From: Jeff Rice
Sent: Thursday, December 3, 2020 8:26 AM
To: Cameron Miller; Kyle Duitsman; Kate Varnum
Cc: Tim McConnell; Elizabeth Nijkamp; Brad Walters; Jeff Hodsdon (jeff@lsctrans.com)
Subject: RE: [External] RE: Falcon Marketplace Paving
Attachments: [IMG_1058.JPEG](#)

From: Cameron Miller <cmiller@evgre.com>
Sent: Tuesday, December 1, 2020 5:24 PM
To: Kyle Duitsman <kyle.duitsman@intertek.com>; Elizabeth Nijkamp <ElizabethNijkamp@elpasoco.com>
Cc: 'Jeff Hodsdon' <jeff@lsctrans.com>; Jeff Rice <JeffRice@elpasoco.com>; Tim McConnell <tmcconnell@drexelbarrell.com>
Subject: RE: [External] RE: Falcon Marketplace Paving

I'm okay with this 5.5" design, but **only** from Sta. 6+00 to Sta. 19+00. The PSI report states that "Concrete pavement at least seven inches thick is recommended for areas which receive continuous repetitive traffic such as entrance/exit drives." With the WIS DOT reference copied below I would like the designers to specifically address the roundabouts and two tight (non-standard) curves in the project. The auxiliary lanes on Meridian Road, decel. lane from Woodmen Road (which should match Woodmen Road pavement section), and the other access road from Meridian (5

NORTH
ROUNDABOUT
PROFILES

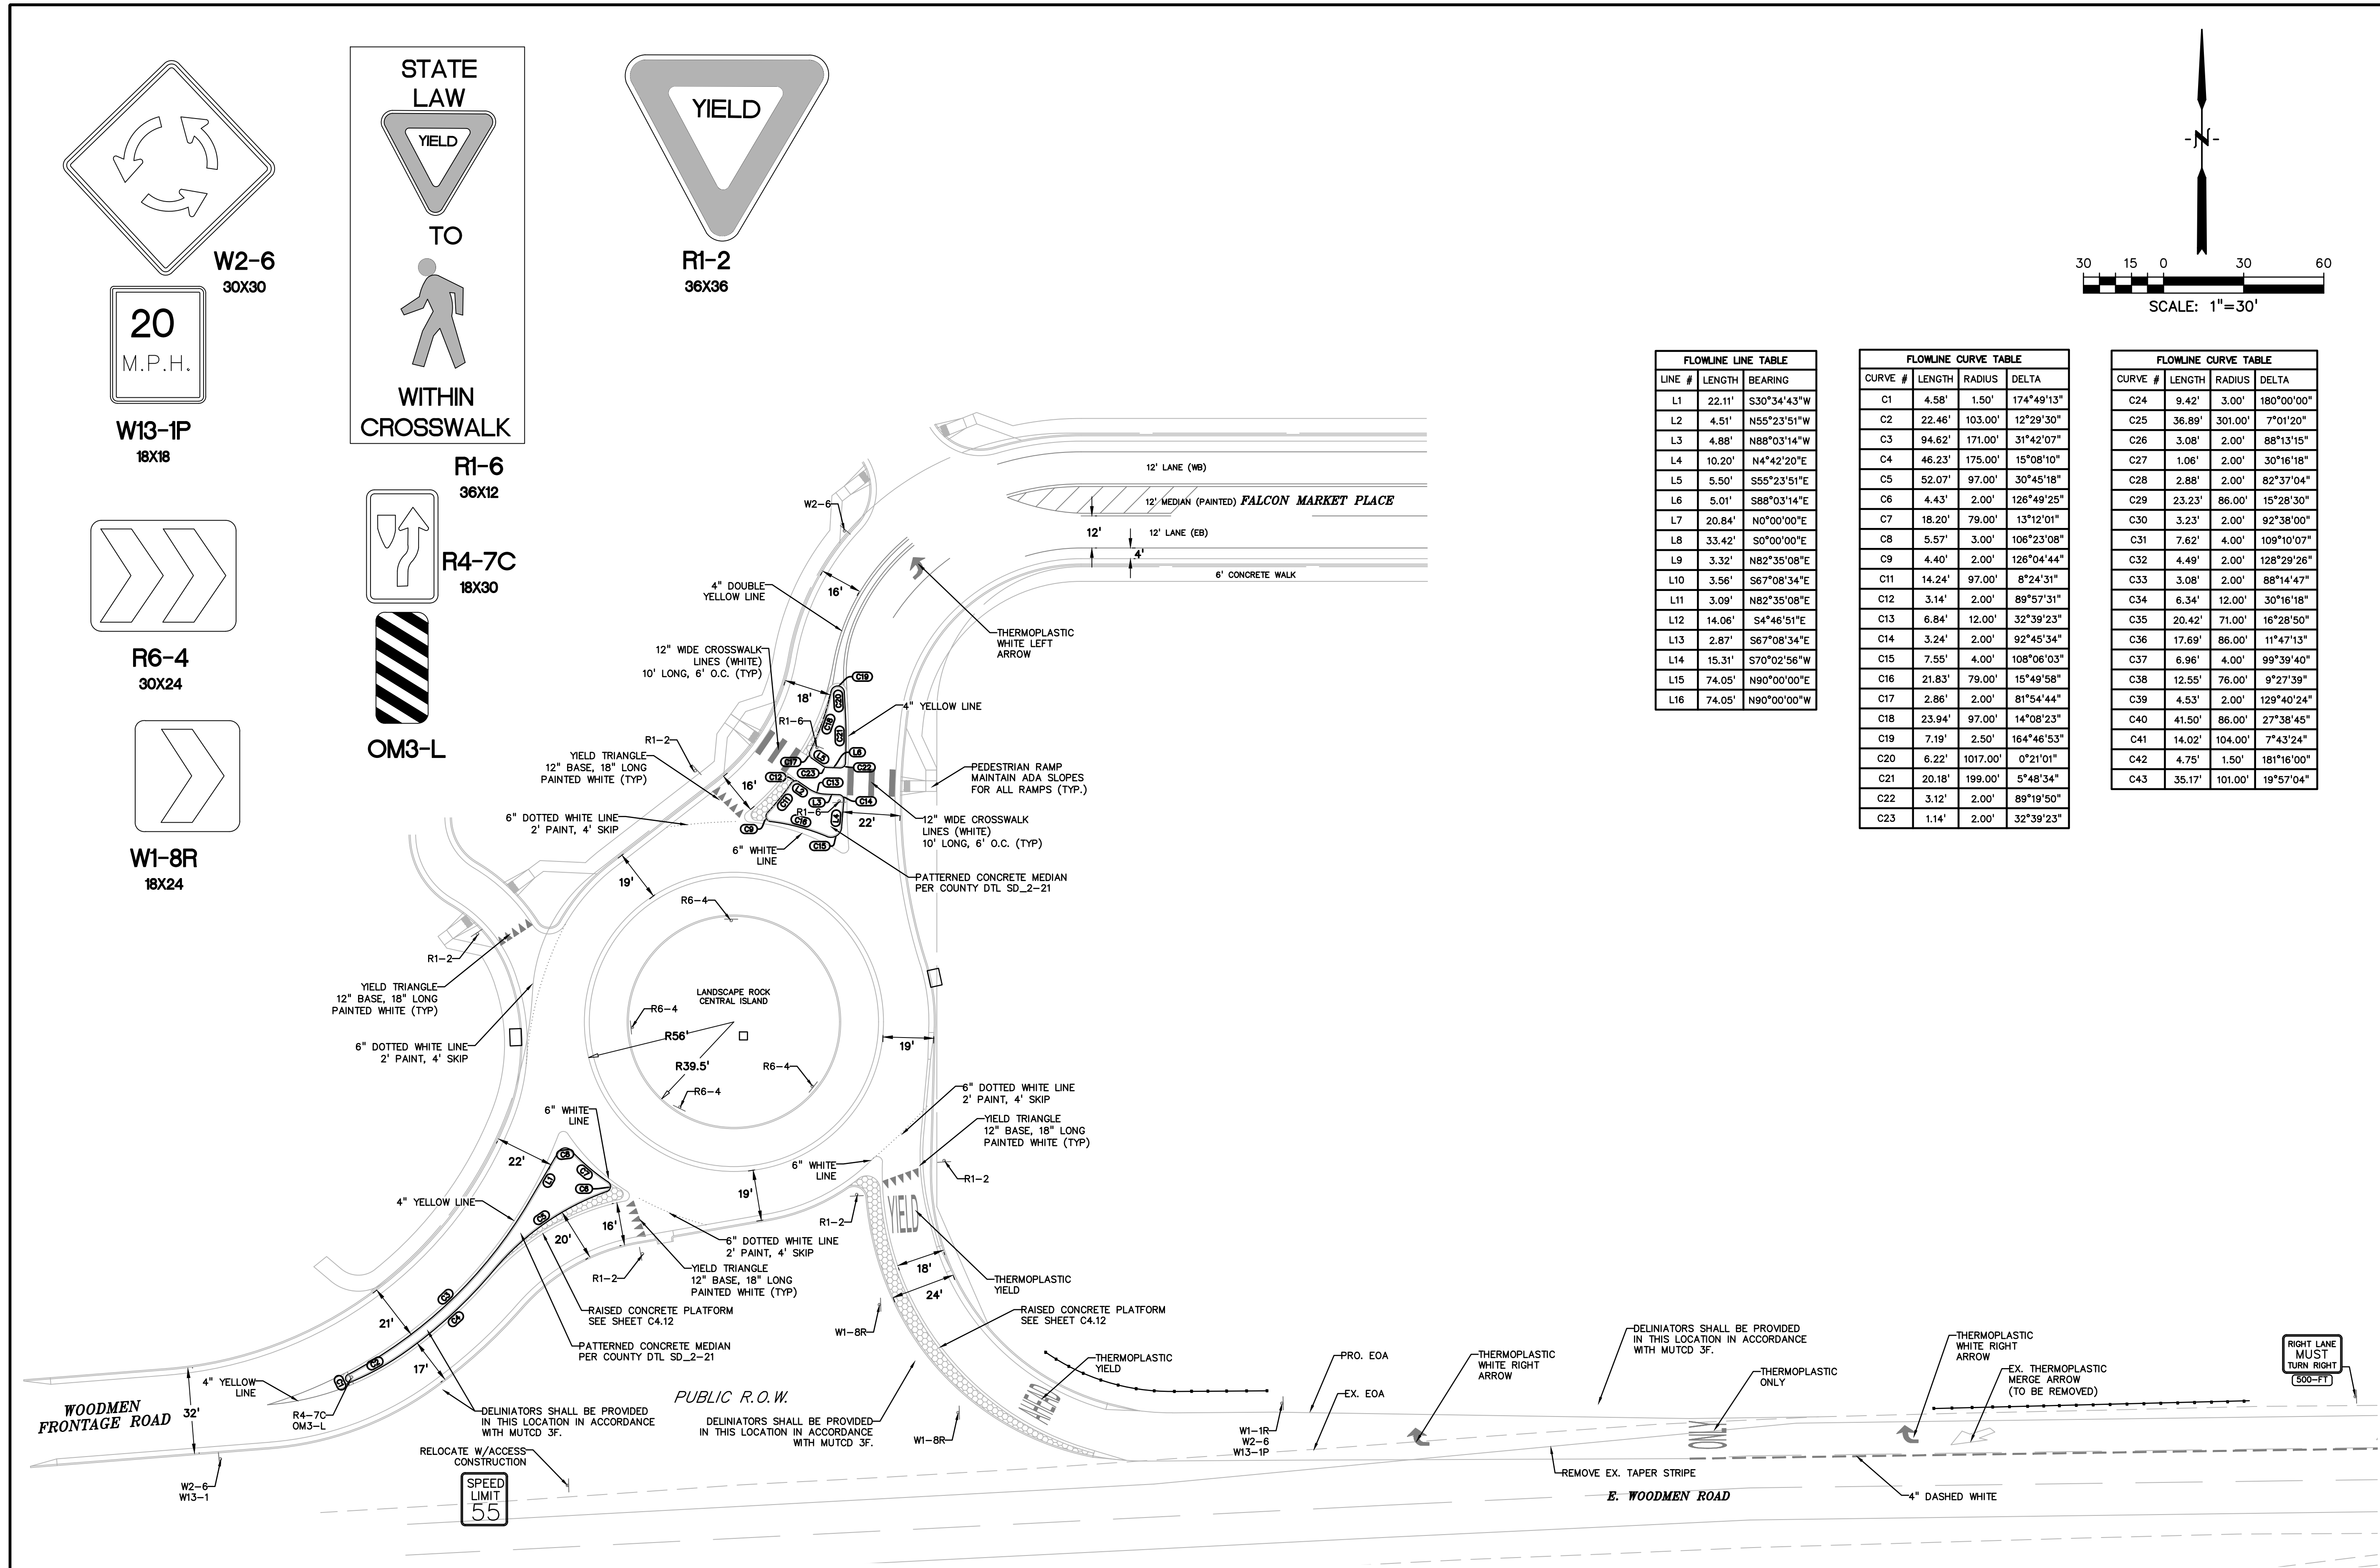
I was at the site a couple weeks ago and it looked like the cross slope on the north side of the north roundabout might be high based on the curb elevations seen in the picture attached. I was just able to go back to the plans and it looks like the cross-slope was changed from about 2% to the steeper slopes several revisions ago and I missed that change during the review process. Please check on what can be done to revise this curb – it looks like about 230 feet on the outside would need to be raised up to half a foot, or the inner curb lowered. I don't know if you've installed the concrete apron yet.

This is a safety concern with large delivery trucks that will be going around the roundabout and could tip over if they use the center island or are going too fast.

SITE PAVING  
& CONCRETE  
PLAN

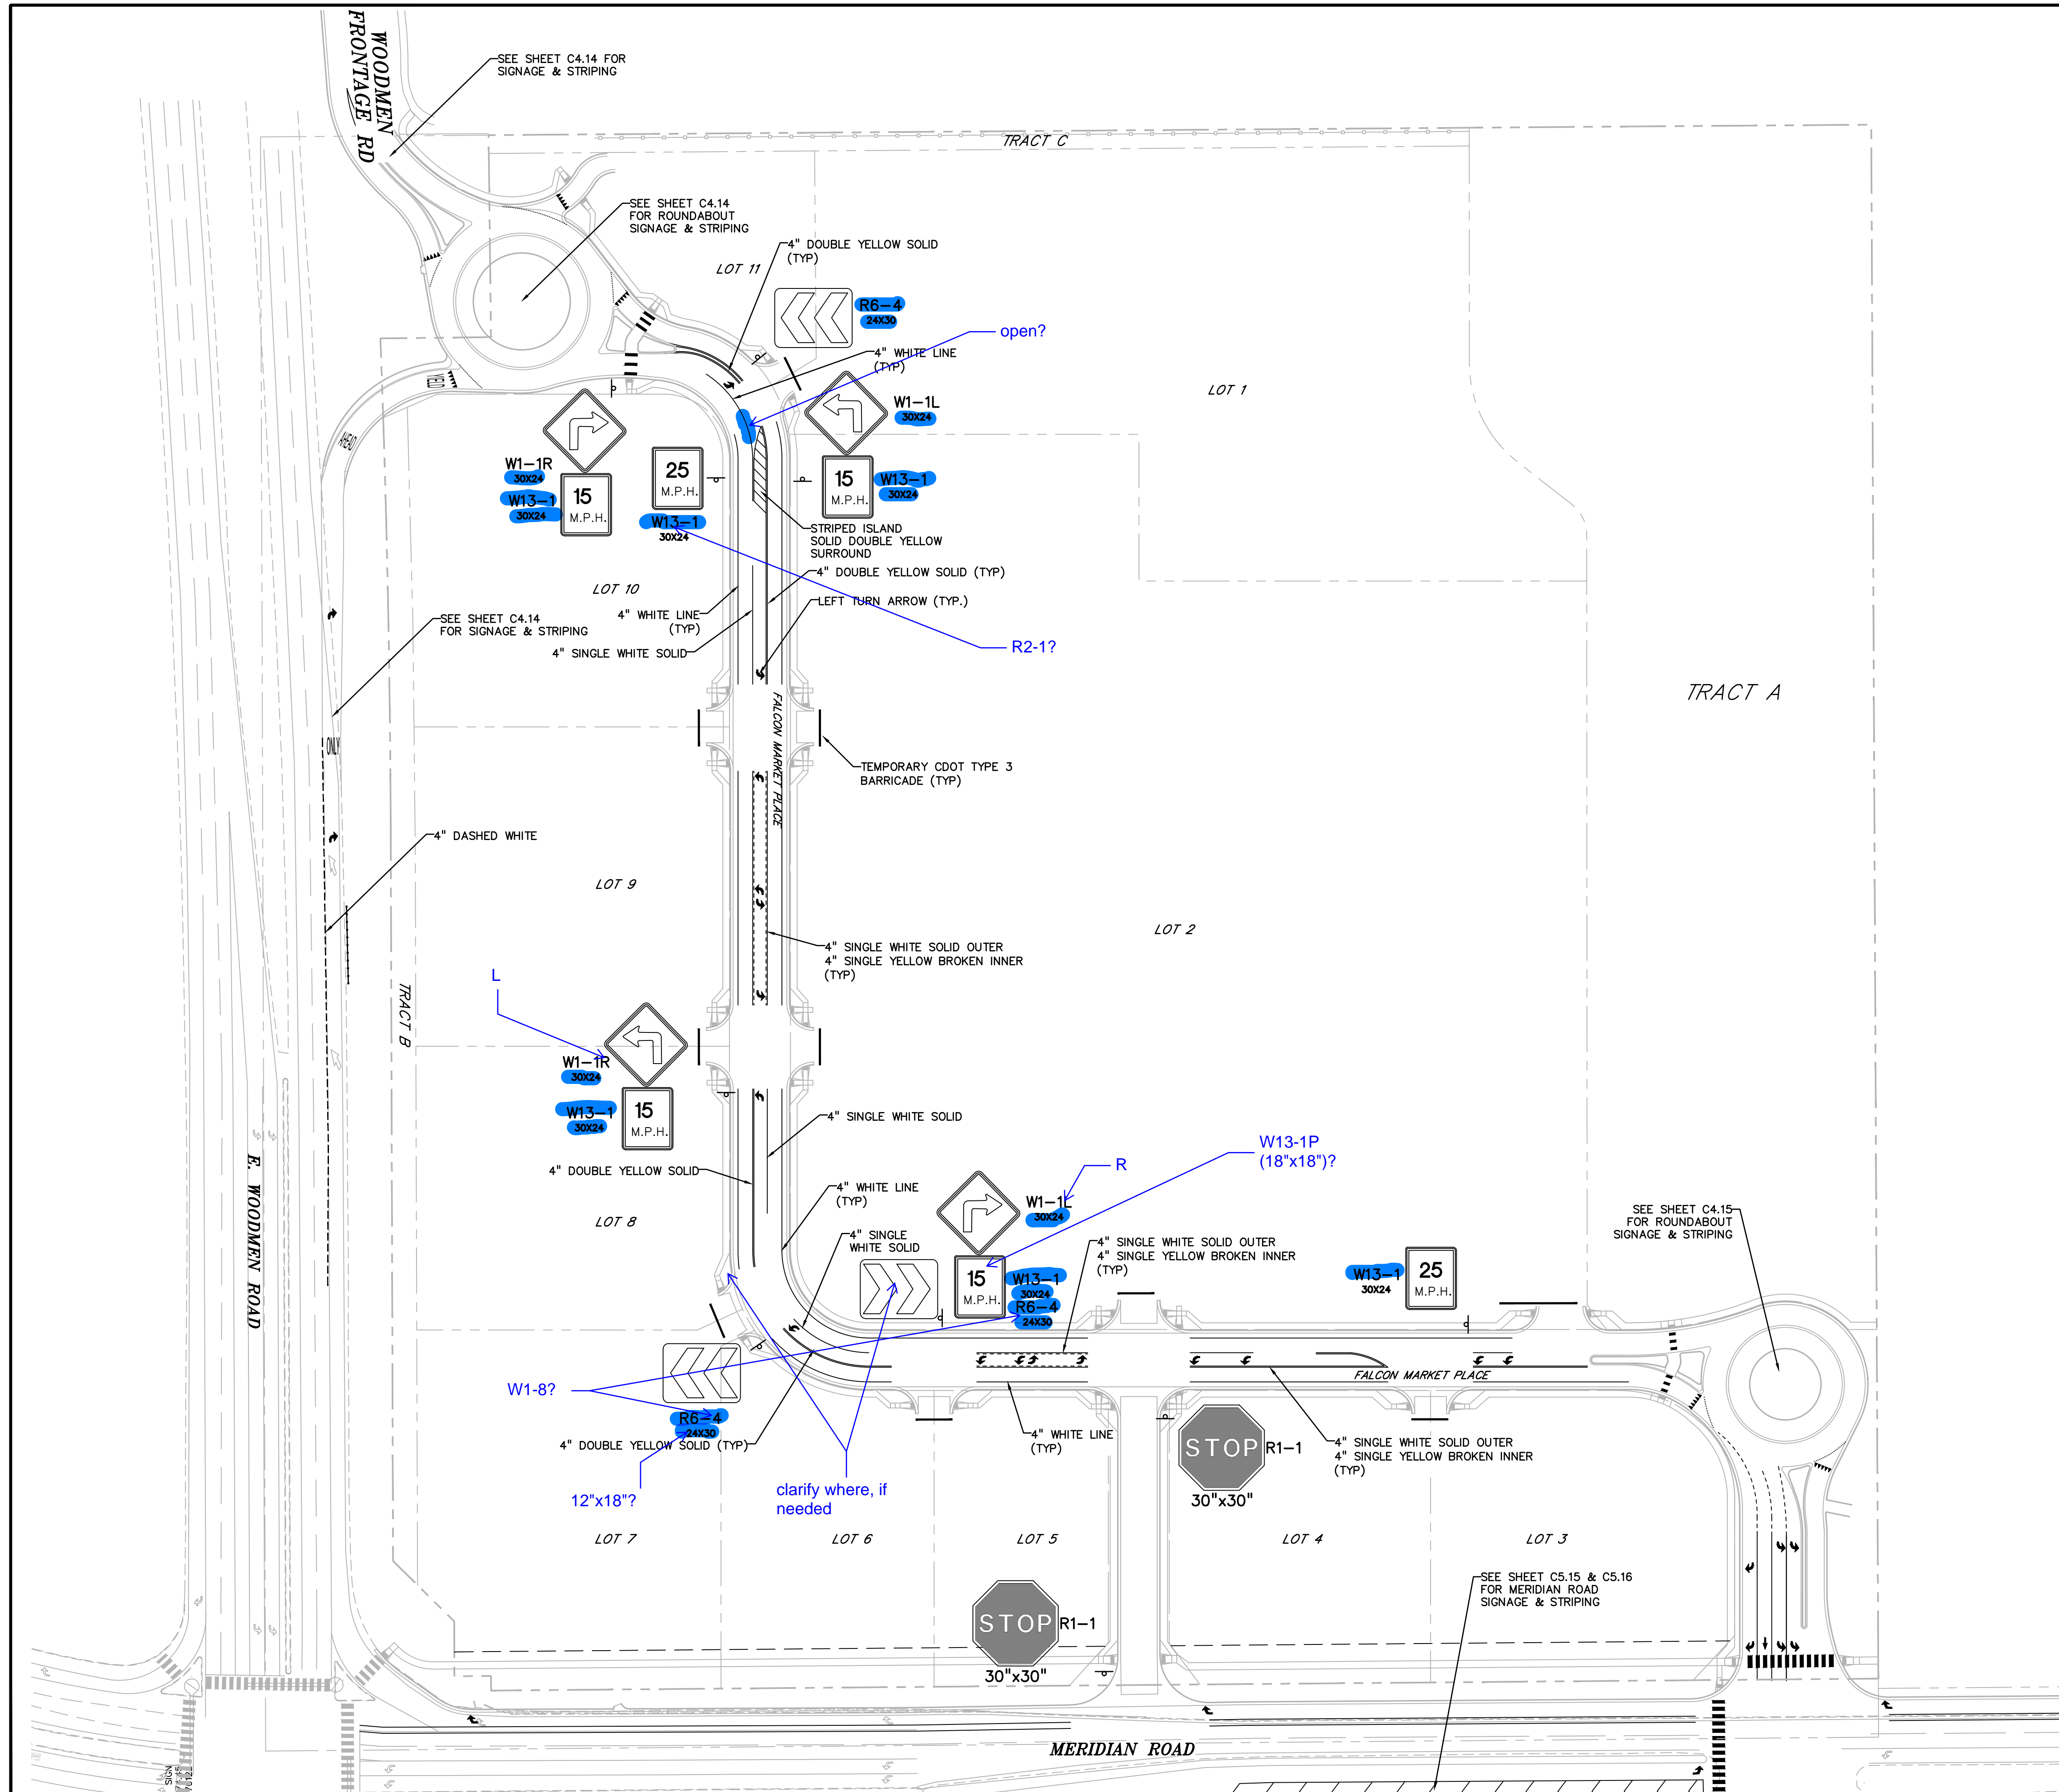
I also don't see Boring 10 (the heaviest traffic area) in the PSI gradation curves/lab test results. The borehole log shows 1 foot of fill over 4 feet of poorly graded sand with silt. I'll try to get hold of PSI staff to ask about that. We have emailed them to get clarification.

Attached please find our revised report. We deleted the sentence regarding concrete thickness for repetitive traffic as it is meant for trash enclosure aprons, loading dock aprons, etc. It does not apply here, we recommend sections be designed for the ESAL's we've discussed previously. Thanks and let me know if you need anything else.
